FLOODLIGHTING AND OBTRUSIVE LIGHT ADDITIONAL INFO

G-234209 EDISFORD PLAYING PITCHES

SYNTHETIC TURF PITCH

DOCUMENT NUMBER	25-0601_Lighting Response	
VERSION NUMBER & DATE	1.0	15/07/2026
REPORTED BY		Tom Would Project Design Consultant (PDC) Tom.Would@labosport.com
APPROVED BY		Louis Keeley Senior Consultant & Framework Manager Louis.keeley@labosport.com

Obtrusive Light Calculations:

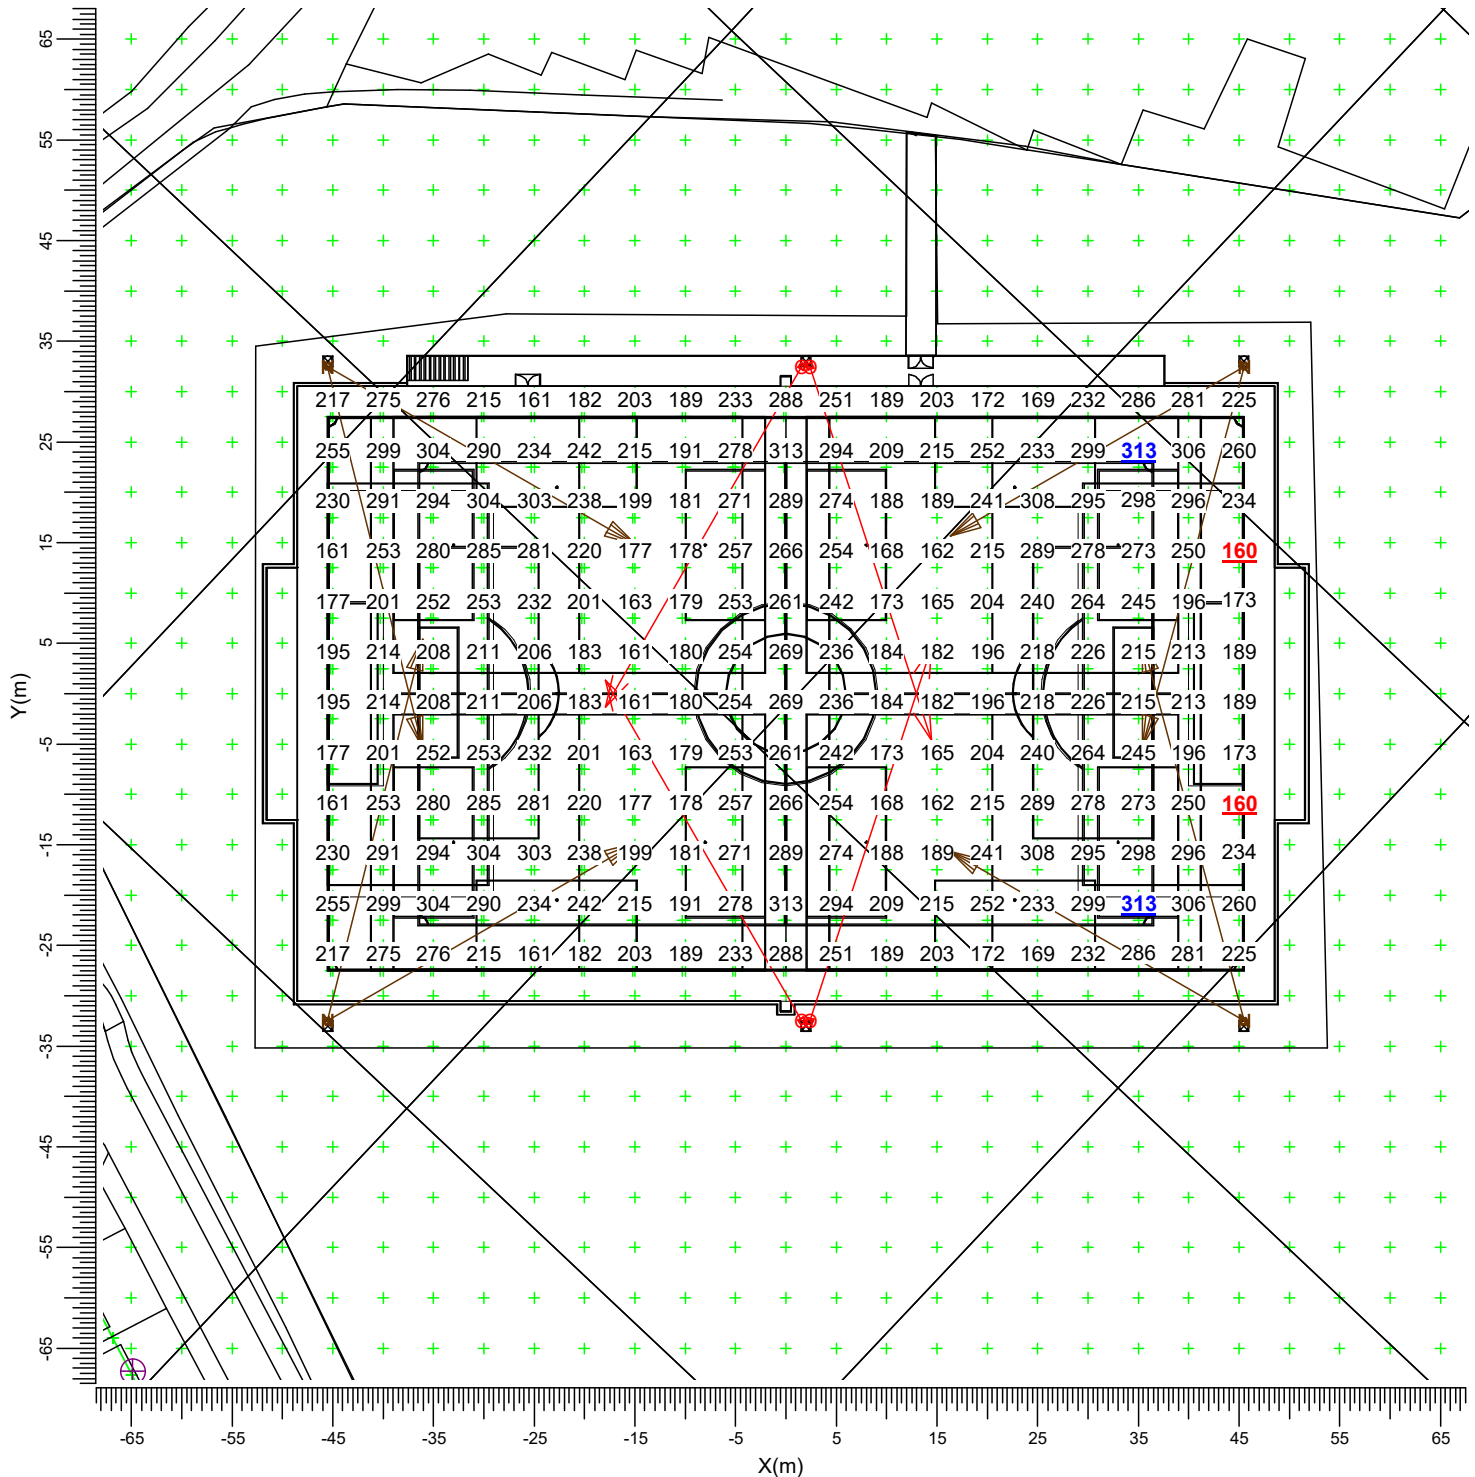
General Information	
PURPOSE OF RESPONSE	This note responds to the Local Planning Authority's comments regarding the proposed floodlighting, including the applicable environmental zone, vertical illuminance at nearby residential properties, luminaire dimensions and intensity, beam control, luminaire aiming, and the proposed luminaire wattage. The applicant has reviewed the previously submitted lighting information and has obtained an updated lighting calculation package. The updated assessment includes nine observer points at the closest residential receptors and provides additional information to assist assessment against the Institute of Lighting Professionals (ILP) guidance. This note should be read alongside: • Updated Lighting Calculation Report: <i>Edisford Playing Pitches – 3G Pitch</i>, dated 13 July 2026; • OptiVision LED Floodlights: <i>Understanding our approach to spill/glare control</i>; • Luminaire dimension drawing; and • The submitted Design and Access Statement.

Lighting Intensity and Glare	
SOURCE INTENSITY	The updated lighting calculation report provides a source-intensity assessment for each of the nine observer points. The reported maximum intensity values range from 878cd to 1,137cd, with the highest reported value occurring at the observer point representing 42 Ribble Prospect. These results should be considered alongside the relevant ILP luminaire-size classification and source-intensity limit. The applicant has provided the luminaire dimensions and updated observer calculations so that the authority can verify the appropriate category and criterion under ILP Guidance Note 01/21. Based on the luminaire dimensions and the relevant ILP GN01/21 luminaire-size category, the applicable E3 post-curfew source-intensity limit is 878cd to 1137cd. The maximum calculated source intensity at the nine residential observer points is 1,137cd. The scheme therefore complies with the applicable ILP E3 post-curfew source-intensity criterion.
